RBBC Action Tracker - Note additional measures may be added depending on the ES.

Topic	Number	Concern	Summary of concern	GAL Comment	Status - Agreed subject to ES, Outstanding or Not agreed
Noise	Noise 1	Noise insulation - Over heating	With increasingly hot summers, and forecast increase in aircraft in the night period 23:00 to 07:00 concerns that the ventilation system provided to people will do nothing to cool the property in the summer months. TWG 4/5/22	The ventilators to be offered are not designed to meet overheating demands in all conditions, instead opening the windows would enable heat to be purged in domestic homes. There are a range of ventilators that can be turned up or down to ventilate noise sensitive rooms. It is envisaged that there would be one per noise sensitive room (living, dining, bedrooms). (TWG 4/5/22)	NOT AGREED - unclear from work to date how the noise insulation scheme will prevent properties from overheating in the summer, given inability to open the windows at night to cool the house down e.g. summer 2022, and issue only likely to get worse than at present.

Title:
Ordnance Survey Base Map Identifying Category 3 and Noise Insulation Scheme Boundary - Sheet 1 of 4

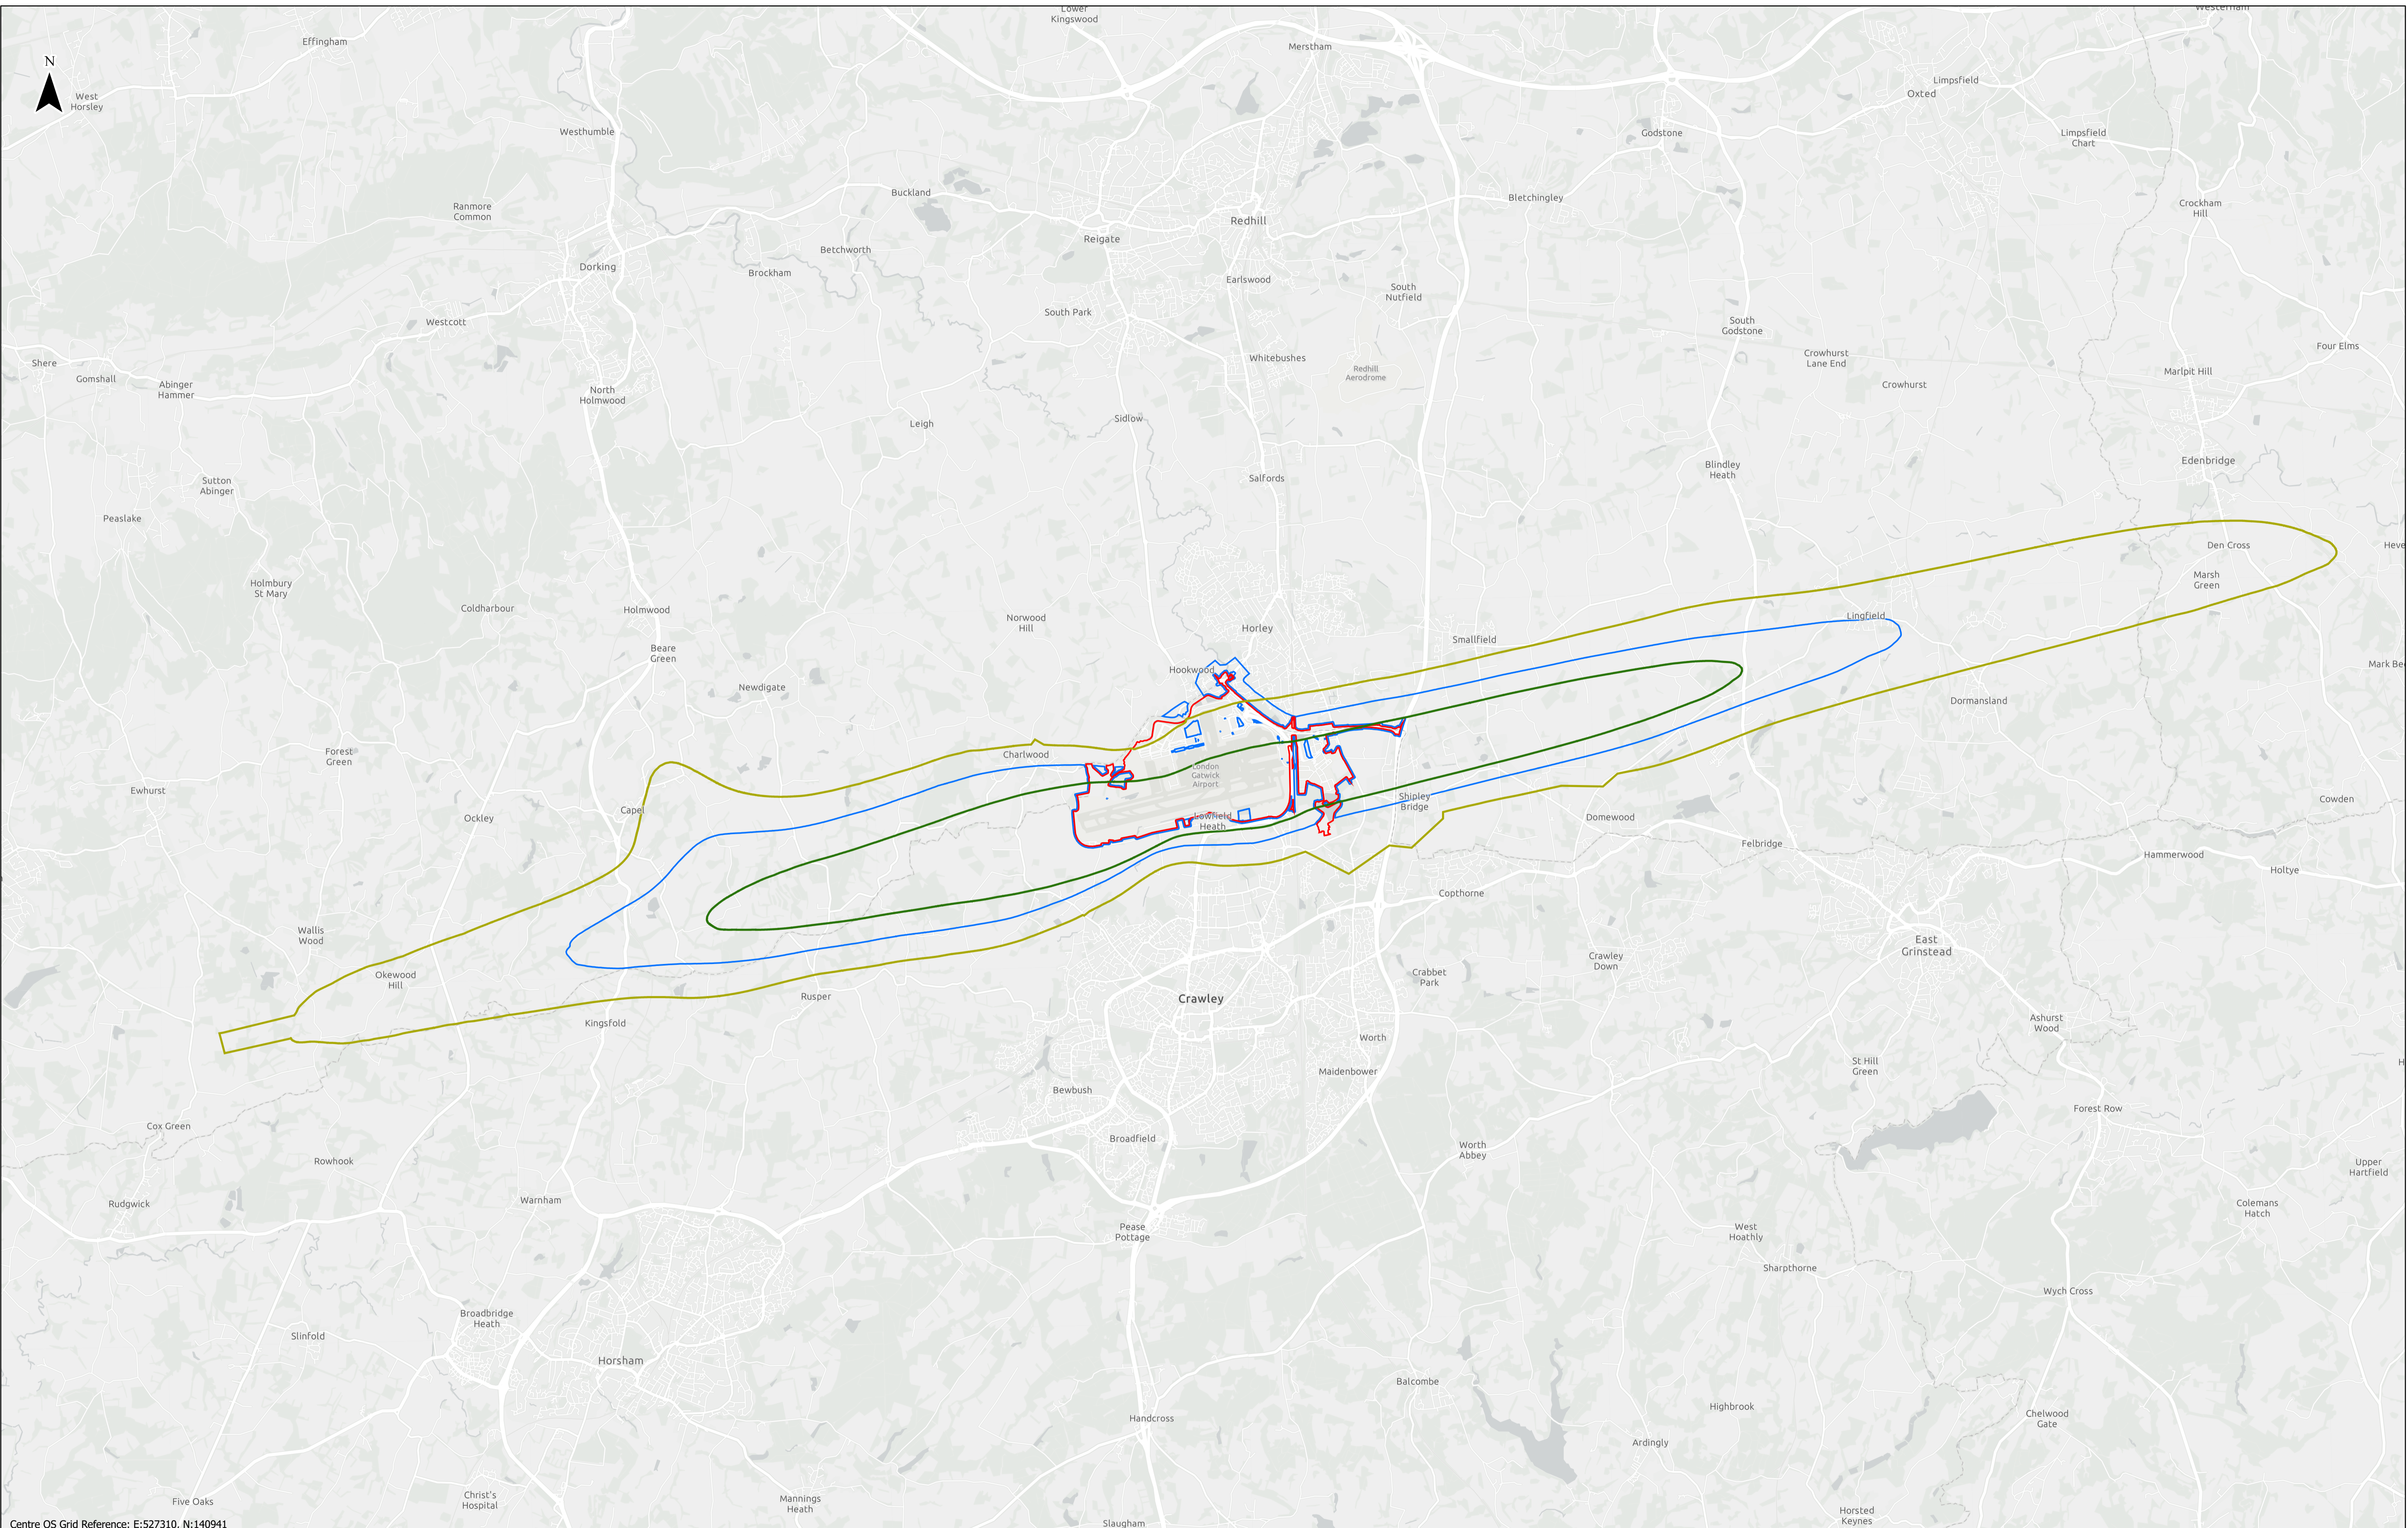
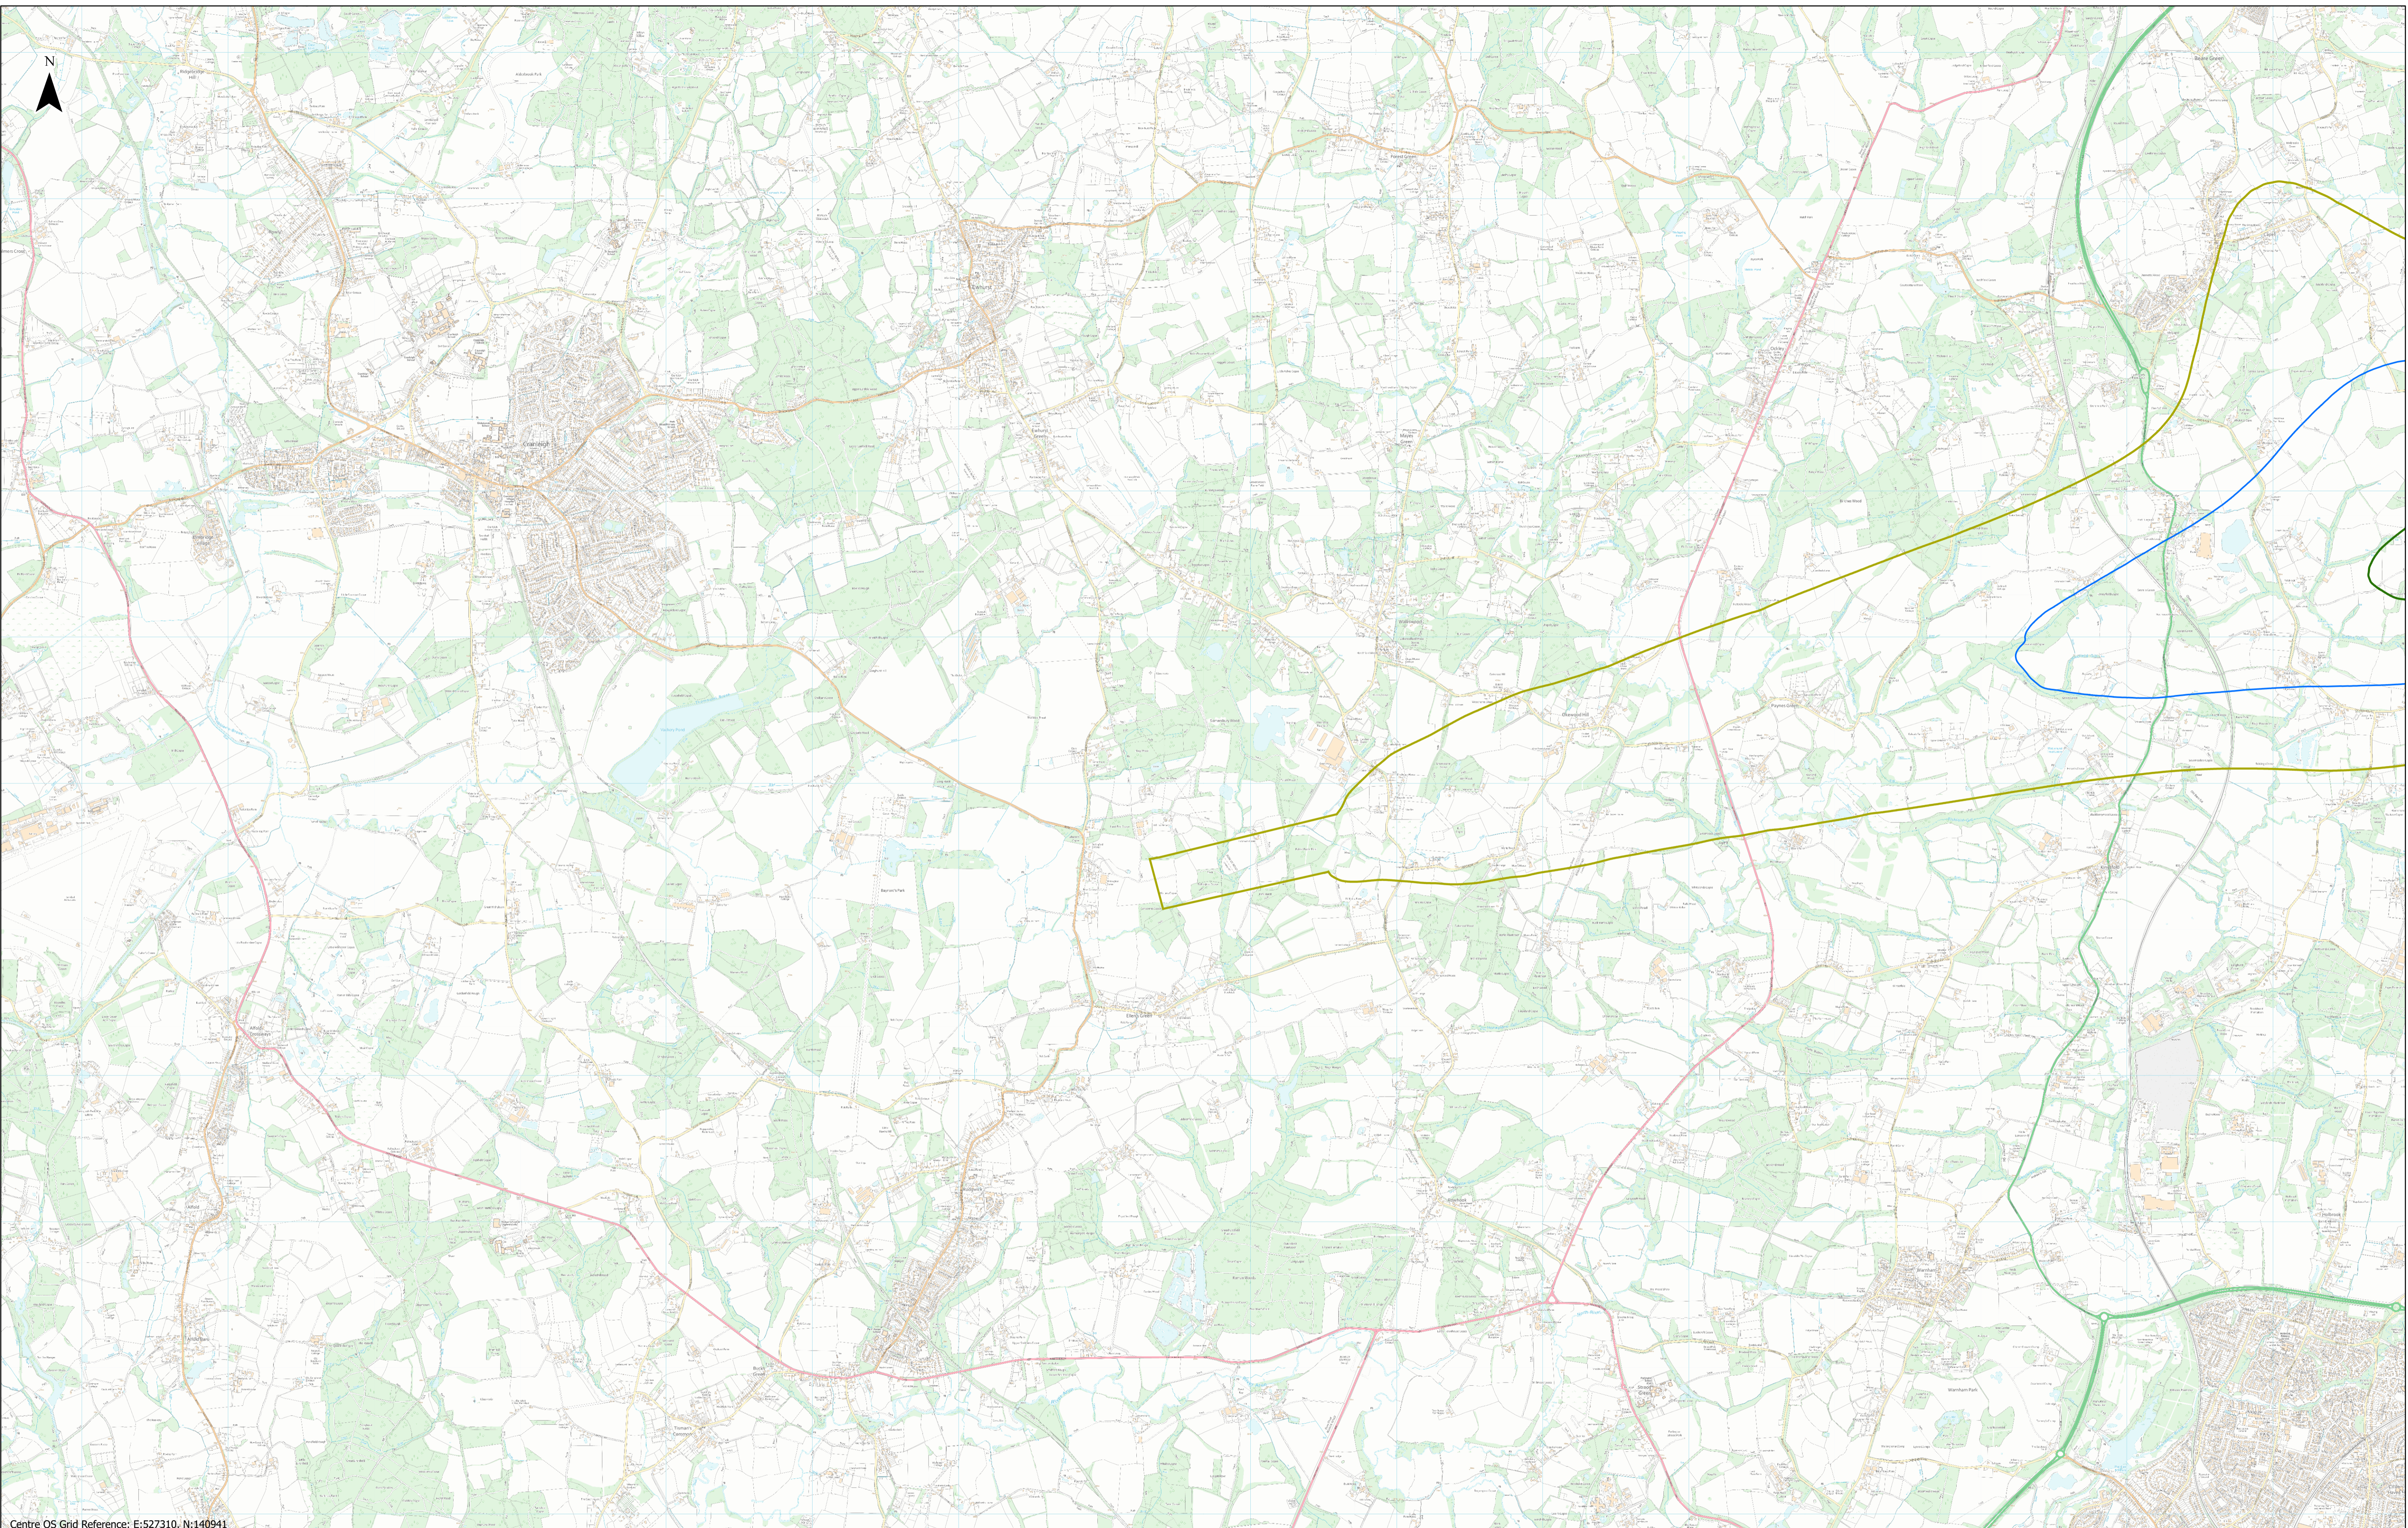
Noise	Noise 2	Noise insulation - levels and compensation	GAL is requested to review the scheme of mitigation and compensation and provide updated proposals having regard to the thresholds of qualifying for grants by applying good acoustic design and the policy of wherever possible improving an area as a result of NRP. This would still allow the airport to increase profitability and in part offset the social cost of the development. As part of this the noise exposure contours are to be produced with the airport operating in single mode to examine worst case daily exposure on a peak summer day and night (for Leq,T and N, above).	GAL has considered the thresholds for noise mitigation carefully and proposed to offer noise insulation at levels below the DfT guidance, i.e. making the scheme more generous than others. The two zone scheme also provides a higher level of mitigation to these worst affected which GAL feels is appropriate. We welcome views on the details of this scheme and will work with stakeholders to develop those details including through discussions at the Noise Envelope Group. We have provided 100% easterly and 100% westerly operations noise predictions for ground noise and operations noise predictions for air noise at the Community Representative Locations (See Appendix 14.2 Section 2, and discussion in para 14.9.67 to 14.9.84) however, these are provided for additional information and not used in the assessment of effects because the accepted criteria for judging those effects are the long-term average not the noise levels on a selection of the days when operations are only easterly or westerly. (August 2022)	Outstanding and subject to ES.

Noise	Noise 3	Noise insulation - scheme flexibility	In terms of the noise insulation scheme it is suggested that the outer zone offer may be more flexible so properties that either already have ventilation or are unable to have ventilation fitted can benefit it an alternate way.	It is expected that very few dwellings already have acoustic ventilation or unable to have it fitted. Details of the final Noise Insulation Scheme will be discussed with the Noise Topic Working Group. (Aug 2022)	Outstanding and subject to ES.
Noise	Noise 4	Noise - recommendation	To prevent and minimise ground noise and air noise impacts on communities to the North, any Northern Runway usage is limited to operations between 07:00 to 23:00 and is only used during the day for Chapter 3 aircraft or quieter.	The proposal is to use the Northern Runway between 06:00 and 23:00 hours to meet the requirements of the project. All aircraft at Gatwick are Chapter 3 or quieter. (Aug 2022)	Outstanding - restriction needs to be placed on the runway for Chapter 3 or quieter given night noise modelling is based on this assumption. Also time restriction needed unless main runway is out of use.
